**Response to Peer Review Comments dated February 7, 2018**  
**Maine Medical Center, East Tower and Visitor Parking**

We are writing to provide supplemental information and respond to review comments presented in a memorandum From Wright Pierce Engineers dated February 7, 2018 regarding the above referenced applications.

EXISTING CONDITIONS SURVEY
 OF: **MAINE MEDICAL CENTER CAMPUS**
 GILMAN ST., CONGRESS ST., BRAMHALL ST., ET AL
 FOR: **MAINE MEDICAL CENTER**
 22 BRAMHALL ST
 PORTLAND, MAINE 04101

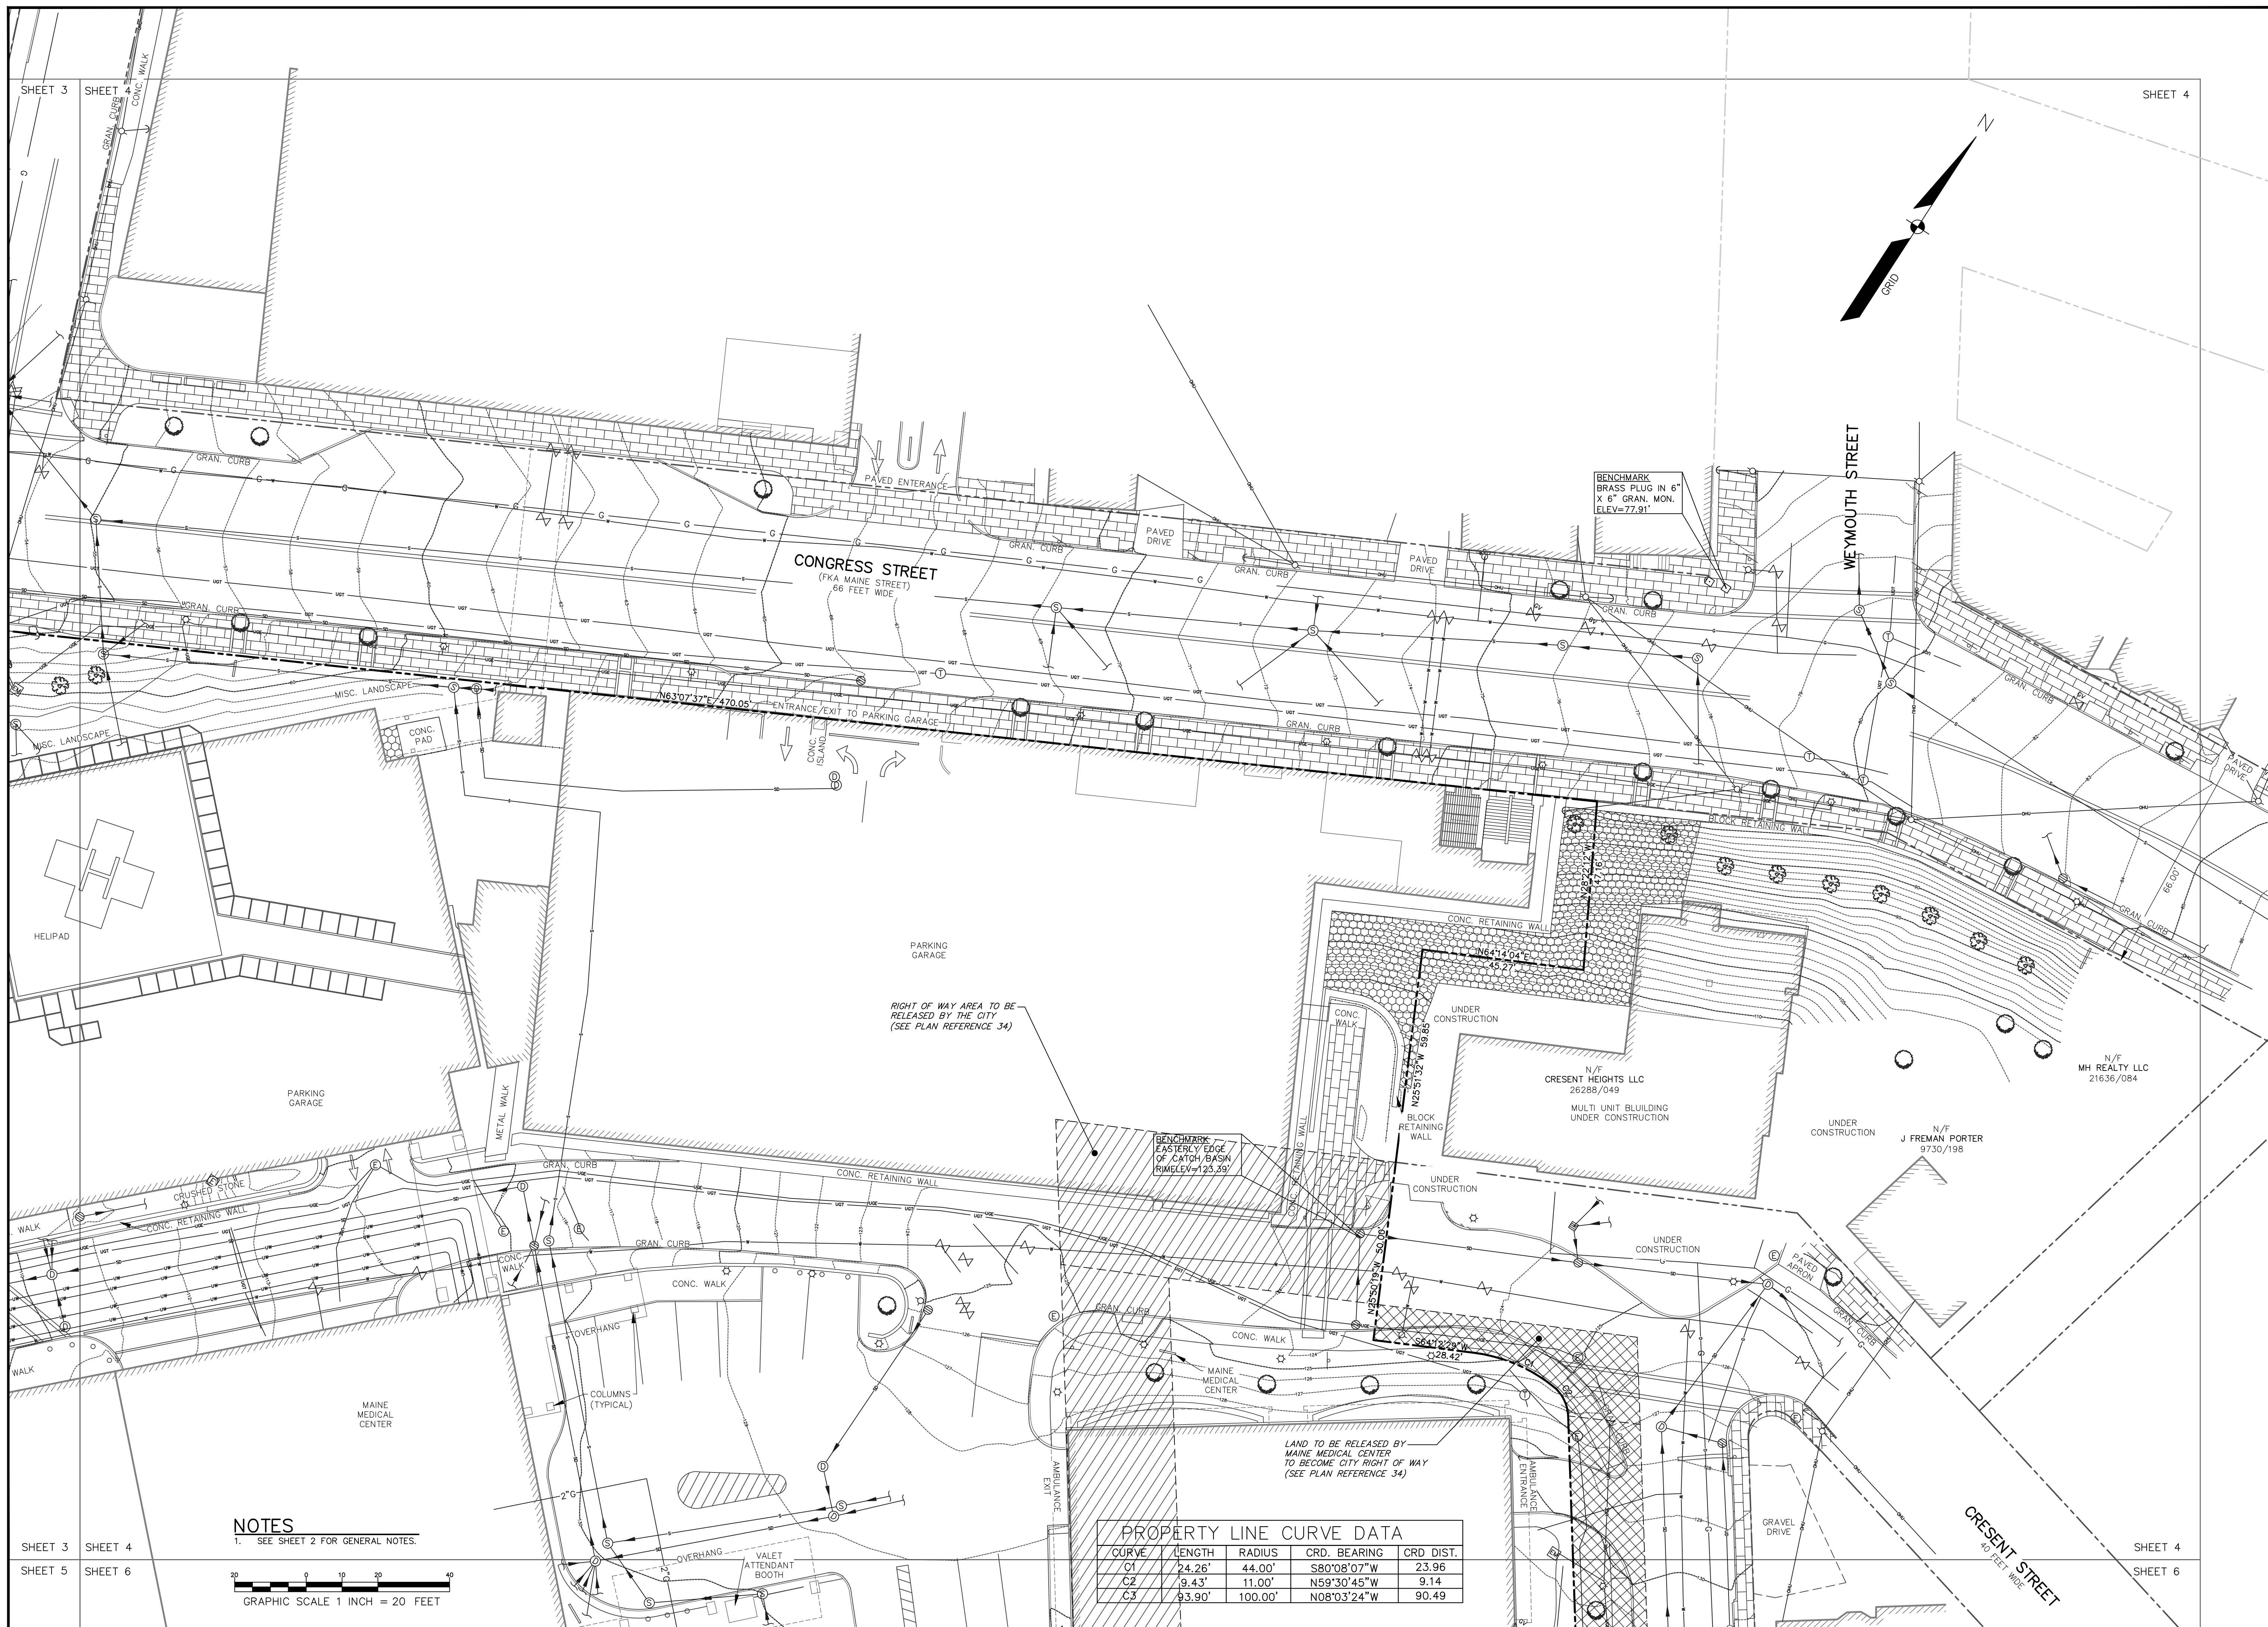
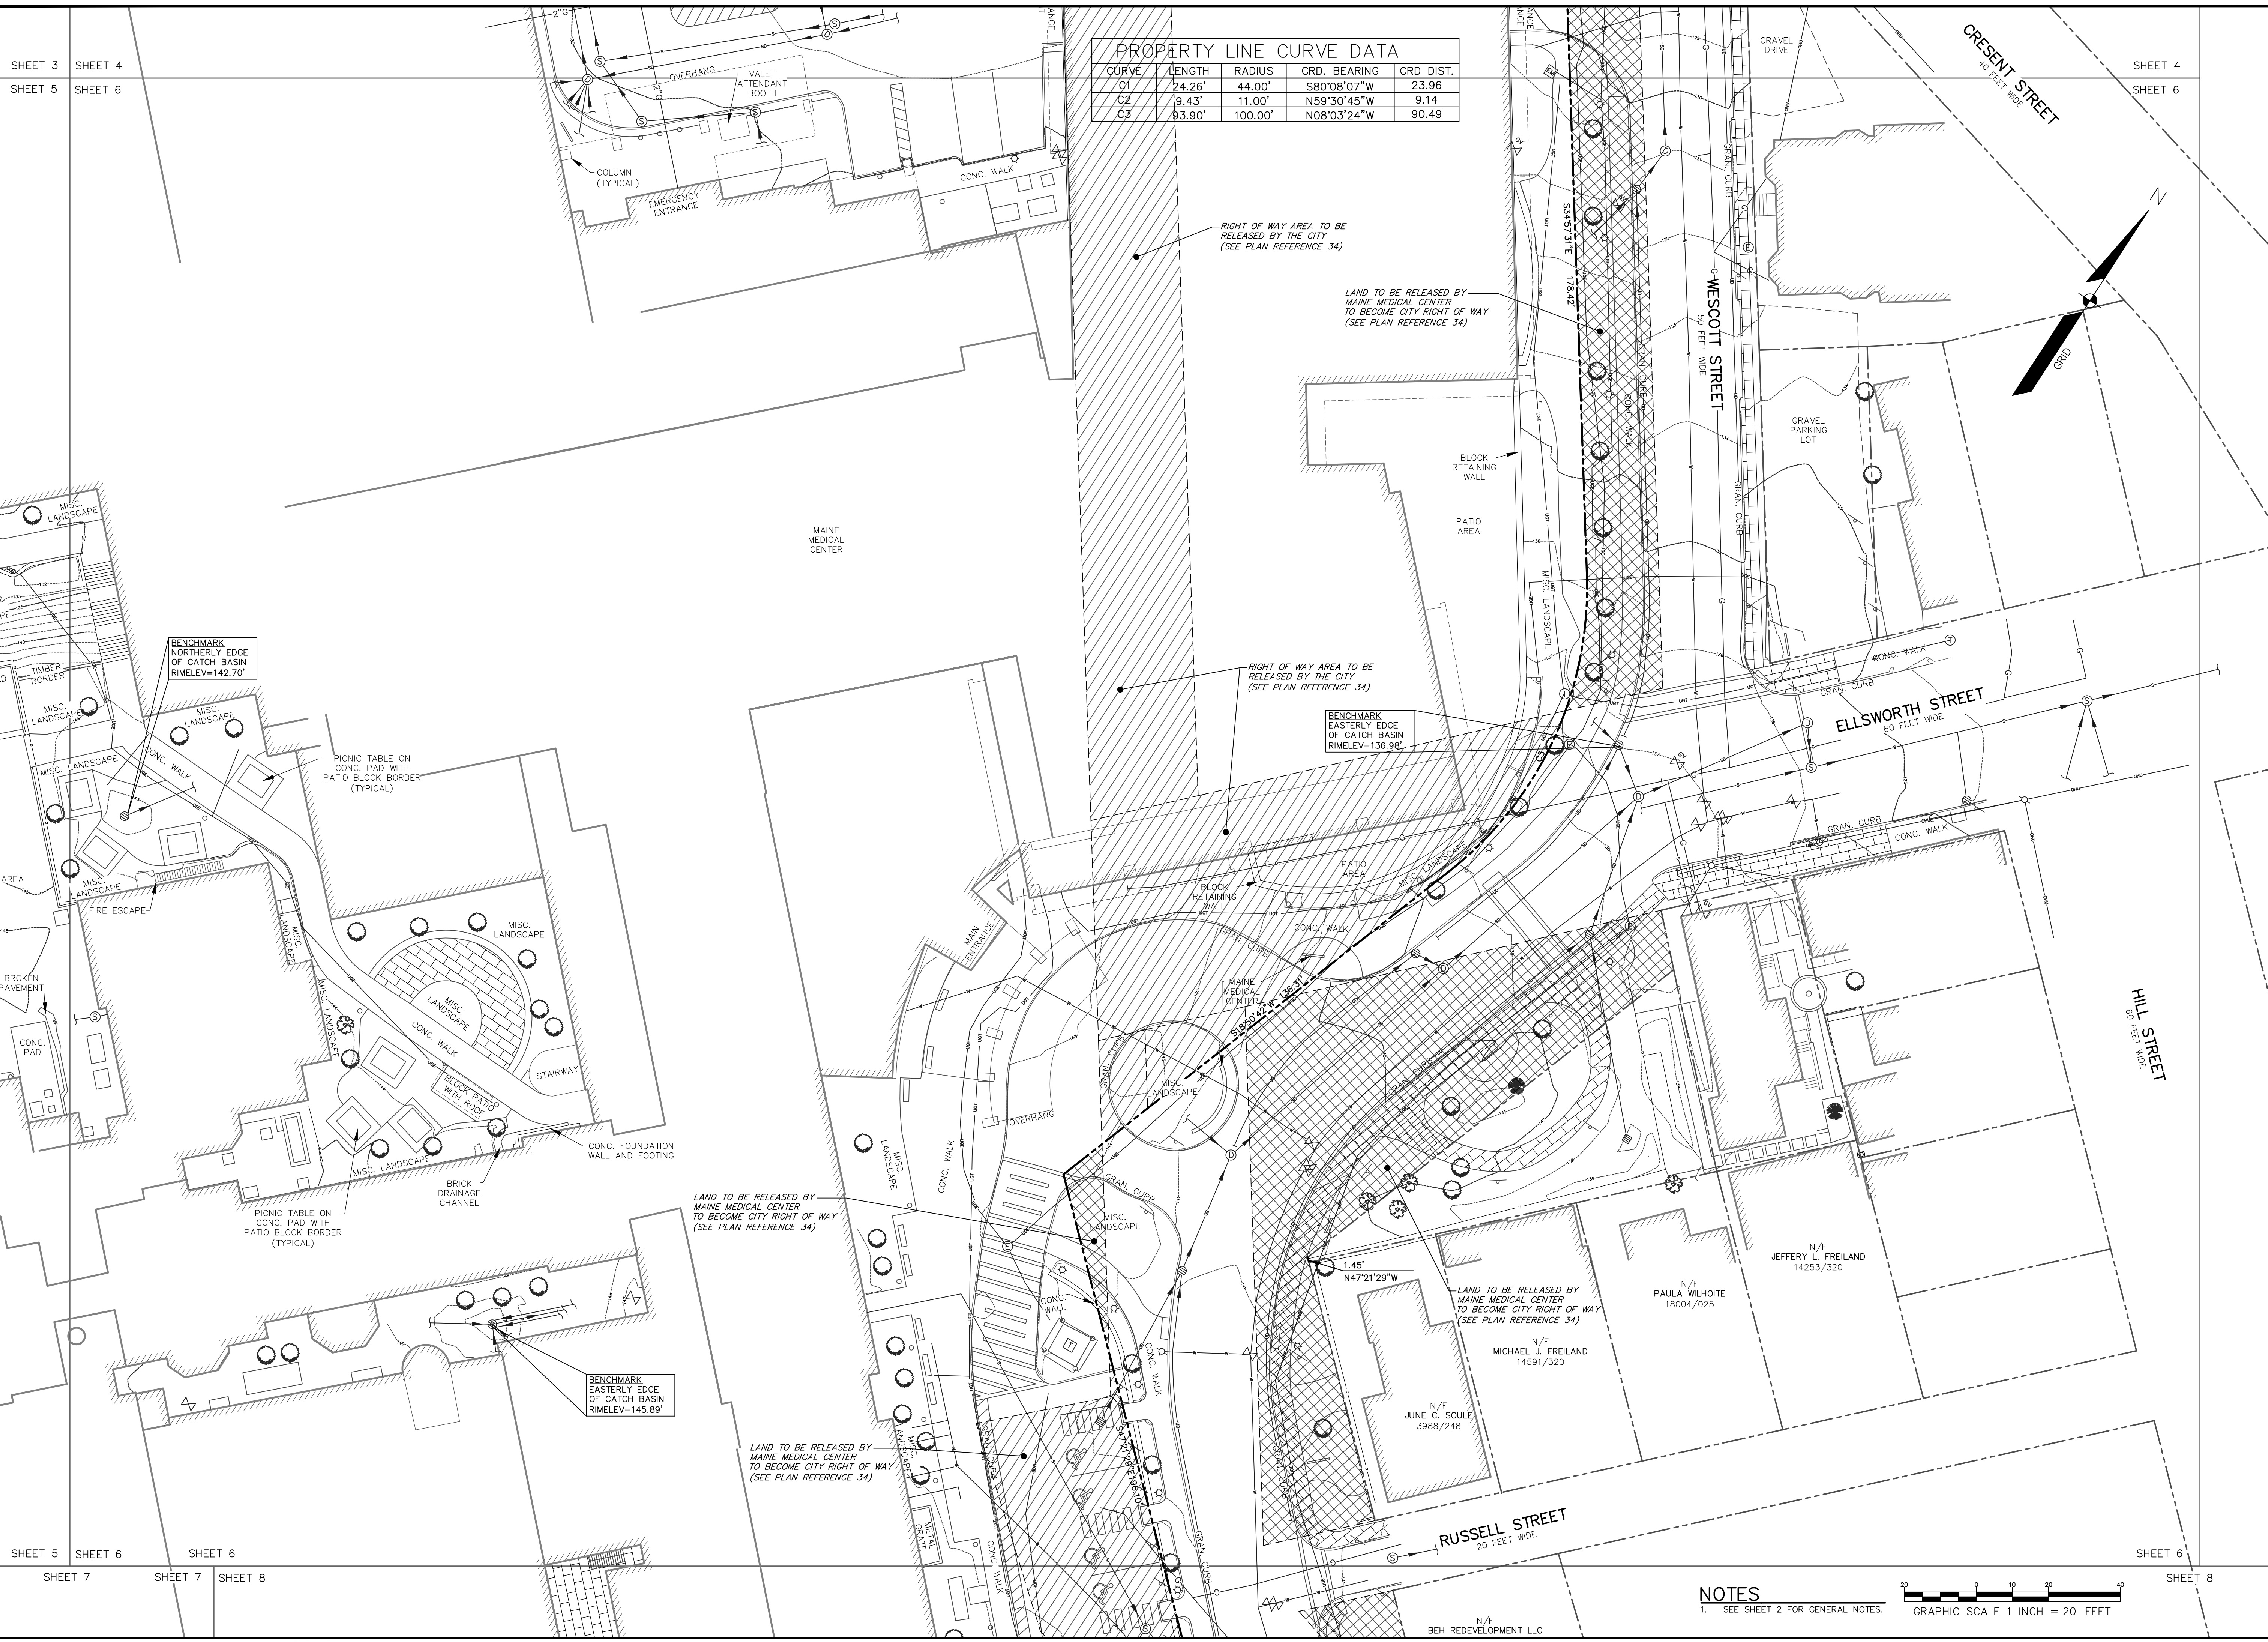
*ii) Plan 2D Boundary Survey indicates a connection or stub connection leading from the catch basin on the south side of the Visitor Garage that may allow for connection from the Visitor Garage roof drain into the separate storm drain system. The applicant shall provide the following:*

*(1) An updated boundary survey in the vicinity of "Plan 2D Boundary Survey" with utility elevations, pipe sizes, and pipe materials in accordance with the City's Chapter 14 and Technical Manual requirements for a Boundary Survey. Anecdotal information regarding the difficulty for construction in this corridor was discussed in the February 1 meeting. However, a sewer pipe crossing currently exists in this corridor, as does a storm drain or storm drain stub. City staff need additional information regarding existing utilities to confirm if a connection to the separate storm drain will be feasible or not.*

A revised boundary survey plan with structures labels as well as rim and invert elevations has been submitted separately.

The staff comments note a drainage stub as a potential connection. We understand this to be a reference to the line shown projecting to the northeast from structure CB#22087 (CB-112). We

have investigated this opening in the manhole. This is not a drain stub that extends as far as the survey plan implies. This line represents the location of a temporary sewer pipe stub that was cored into the structure during the 2004-2007 construction as temporary means to convey a former sewer in this location to Gilman Street, while the Visitor Garage and the permanent sewer was under construction.

It appears that this opening is generally oriented toward the adjacent sewer manhole. The stub was cut and capped and sealed close to the structure after construction and prior to the installation of the adjacent sewer manhole, electrical manholes and duct banks. We believe that access to this entrance into the manhole is now obstructed by these other structures. Due to the tight clearances of the subsurface utilities in this area, excavations were backfilled with flow able concrete fill in this area.
